Our Ref: R/78/19/HH
Your Ref:

Town & Country Planning Act 1990 (as amended)
Town & country Planning (Development Management Procedure) (England) Order 2015
Application for Planning Permission for Works or Extension to a Dwelling

Development Pitch roof side extension to replace existing garage and store
Location 17 Mill Lane Rustington

Block Plan

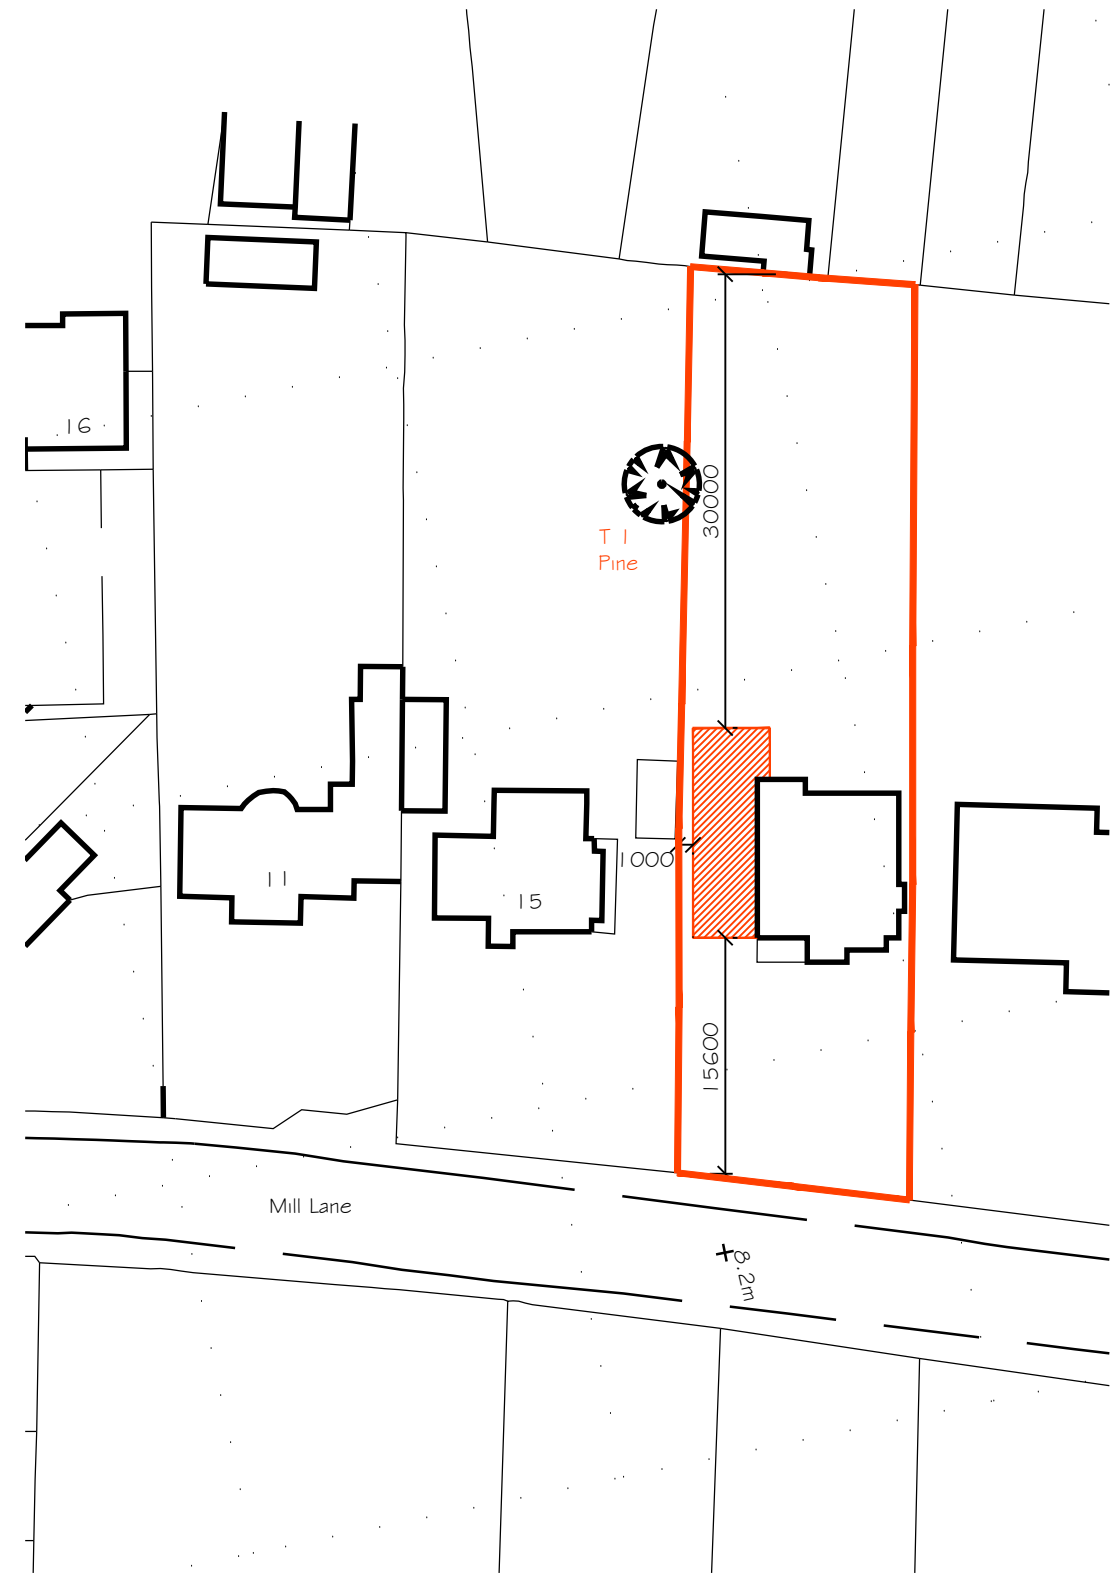
Block Plan

Please include the additional side and rear dimension on the block plan.
